PLANNING APPLICATION REPORT

REF NO: **AW/269/11/**

LOCATION: Land to the rear of
 259A Aldwick Road with access
 from Countisbury Close Aldwick

PROPOSAL: Removal of existing detached garage & proposed single residential dwelling (re-submission of AW/110/11/).

Site Layout Plan at 1:200 scale

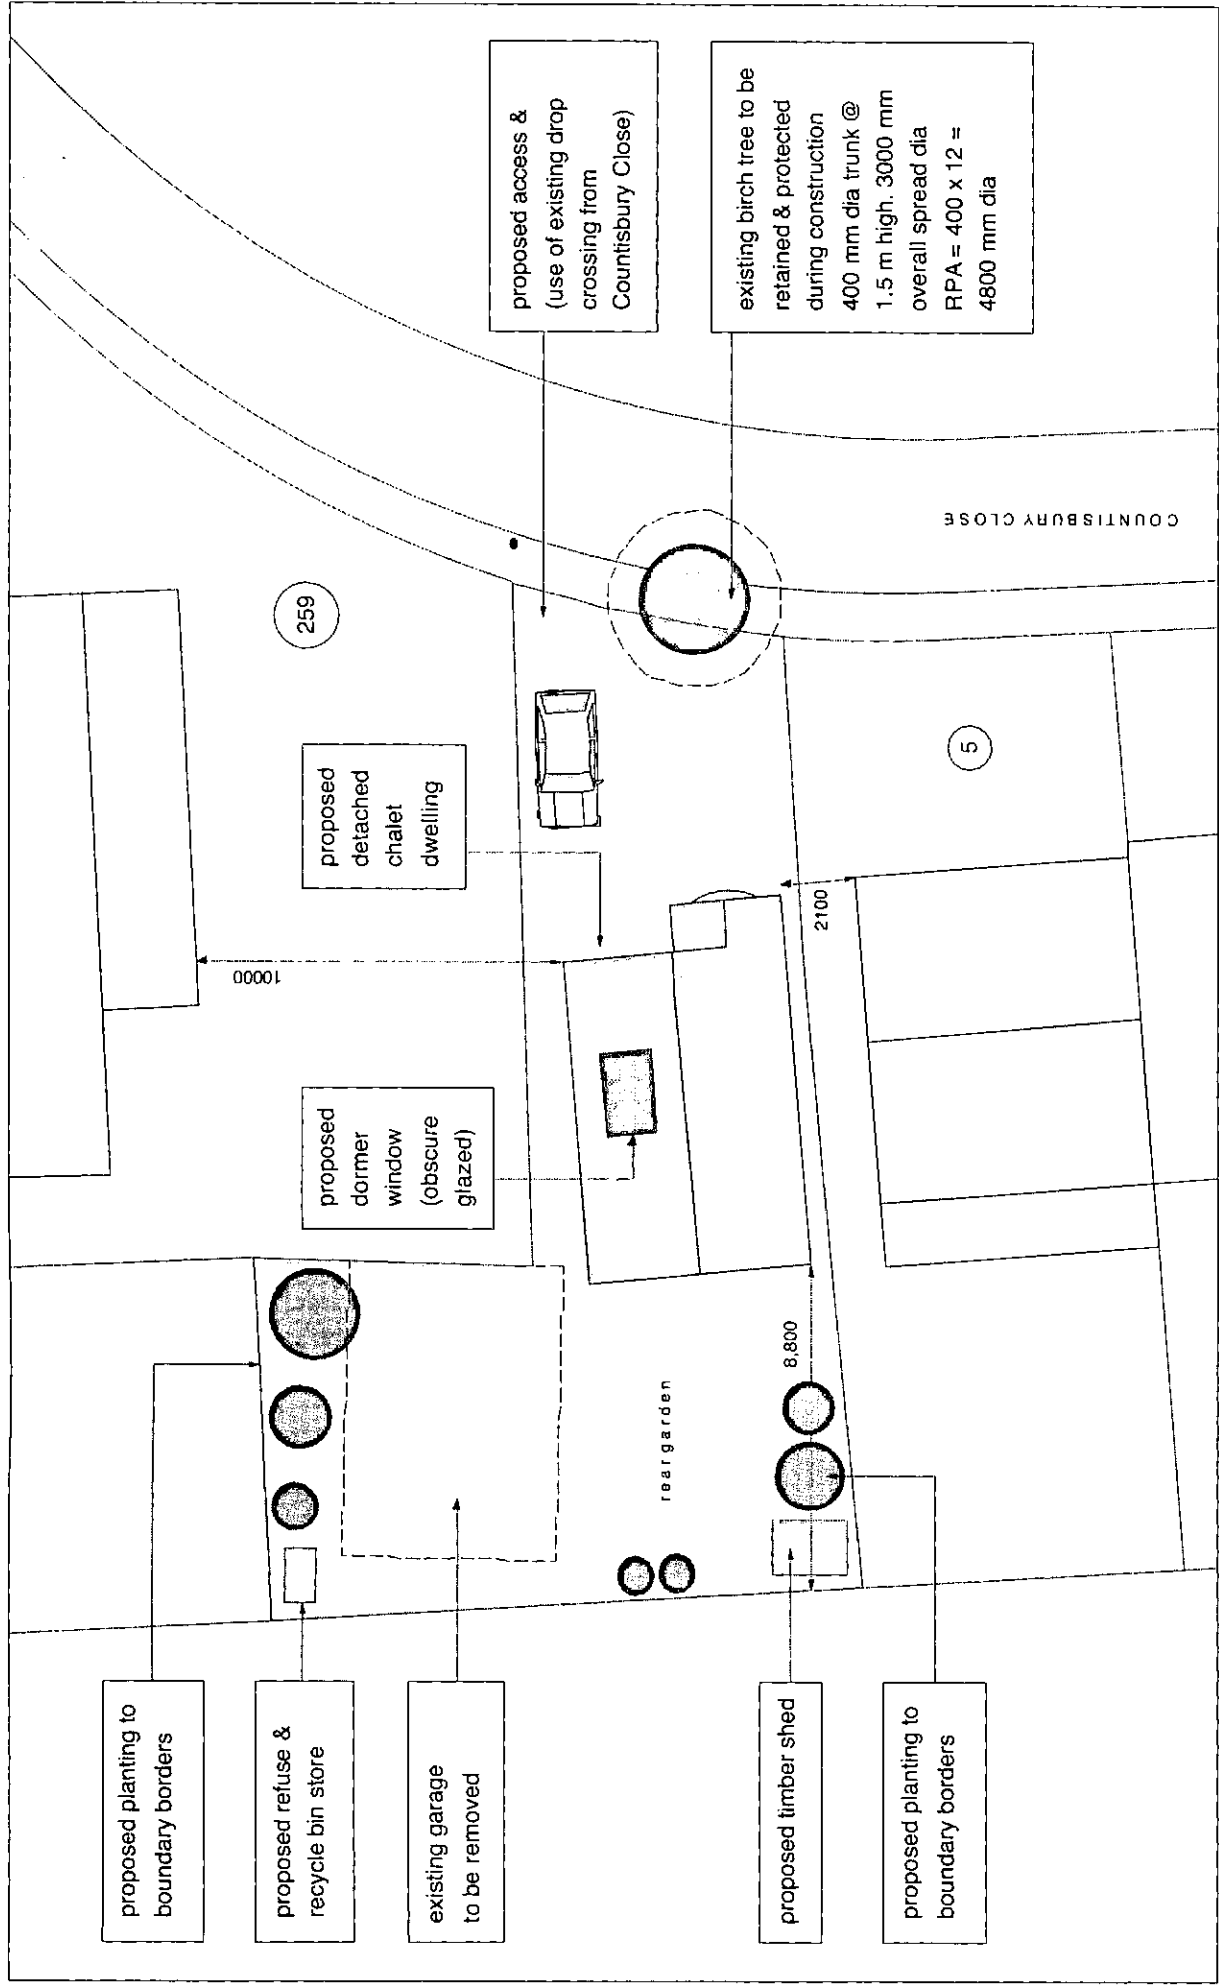
There are no proposed changes to the existing access onto Countisbury Close and the property has parking provision within the site. The Birch tree to the front of the site is to be retained with refuse and recycle bin storage being provided to the rear of the site.

- 7 The dwelling shall not be occupied until the parking space shown on the submitted plan has been provided and constructed. The area of land so provided shall not thereafter be used for any purpose other than the parking of vehicles.

Proposed North (Side) Elevation at 1:100 scale

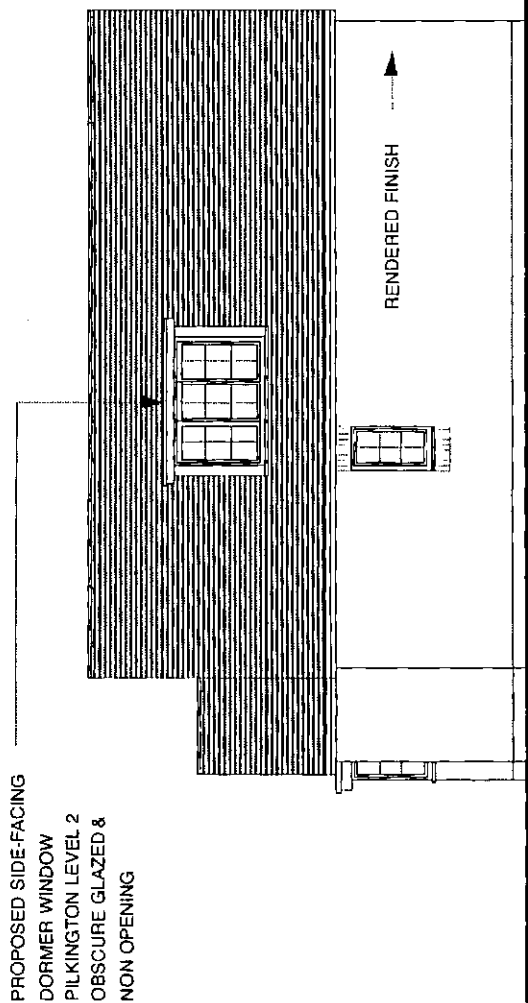
The neighbouring property No 5 Countisbury Close is sited approximately 2.1m away and this property has an obscure glazed window on the ground floor facing the application site. With its hipped roof, lower height and the absence of windows at first floor level on the north side flank wall of the dwelling it is not considered that the residential amenities of the occupiers of this property would be detrimentally harmed by way of overbearing affect, harmful overshadowing, overlooking and loss of privacy. With the removal of the garage it would leave a substantial gap between No 259A Aldwick Road and with a distance of approximately 10m between its north facing flank wall and the rear elevation of flats at 259 Aldwick Road it would retain a visual break when viewed from Countisbury Close and No 259 would still appear as a prominent feature in the street scene which addresses the issue raised by the Inspector in relation to the proposed dwelling and its affect on the setting of No 259.

- 5 The dormer window on the north side elevation of the dwelling shall at all times be glazed with obscured glass and fixed to be permanently non-opening.

Proposed South (Side) Elevation at 1:100 scale

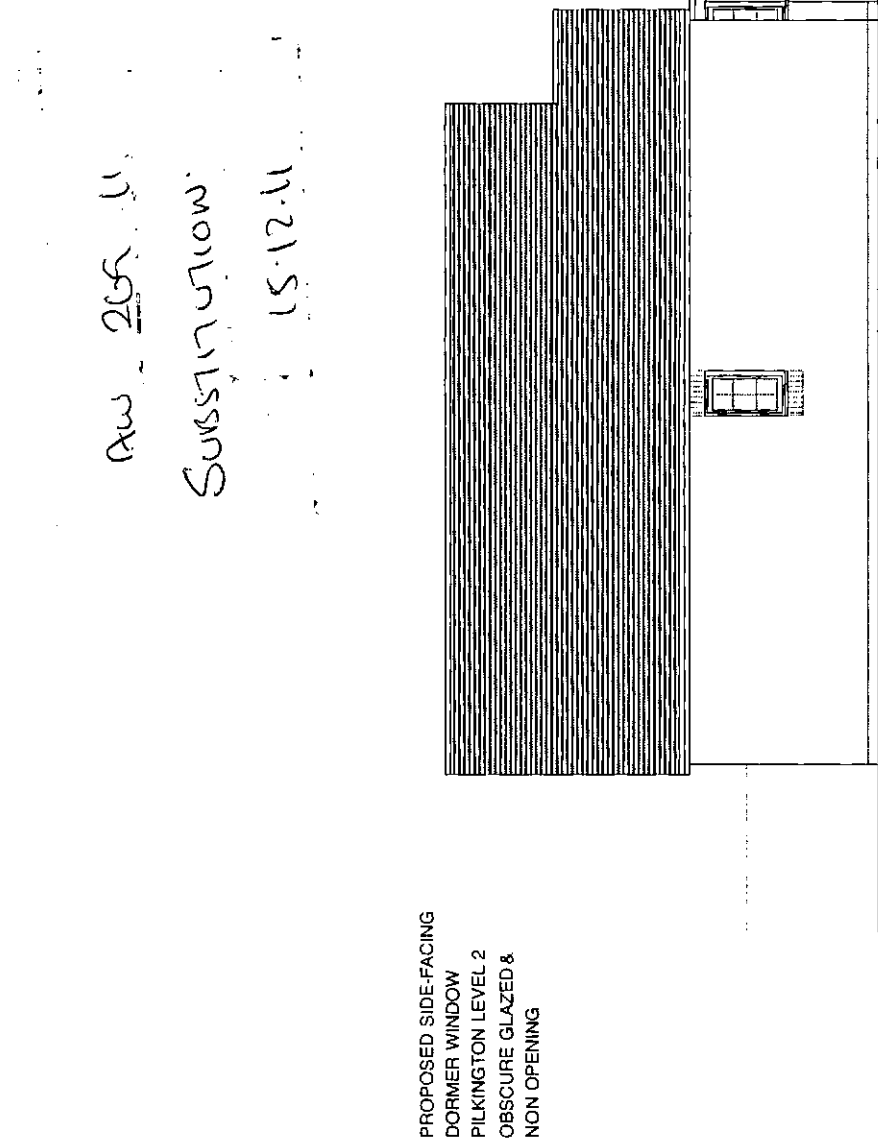
The dwelling would be set in line with the neighbouring property No 5 and sited approximately 2.1m away so it is not considered that this would create any harmful overshadowing or loss of light.

- 4 No windows (other than those shown on the plans hereby approved) shall be constructed in the south side elevation of the dwelling hereby permitted which adjoins the side boundary with No 5 Countisbury Close without the prior permission of the Local Planning Authority on an application in that behalf.
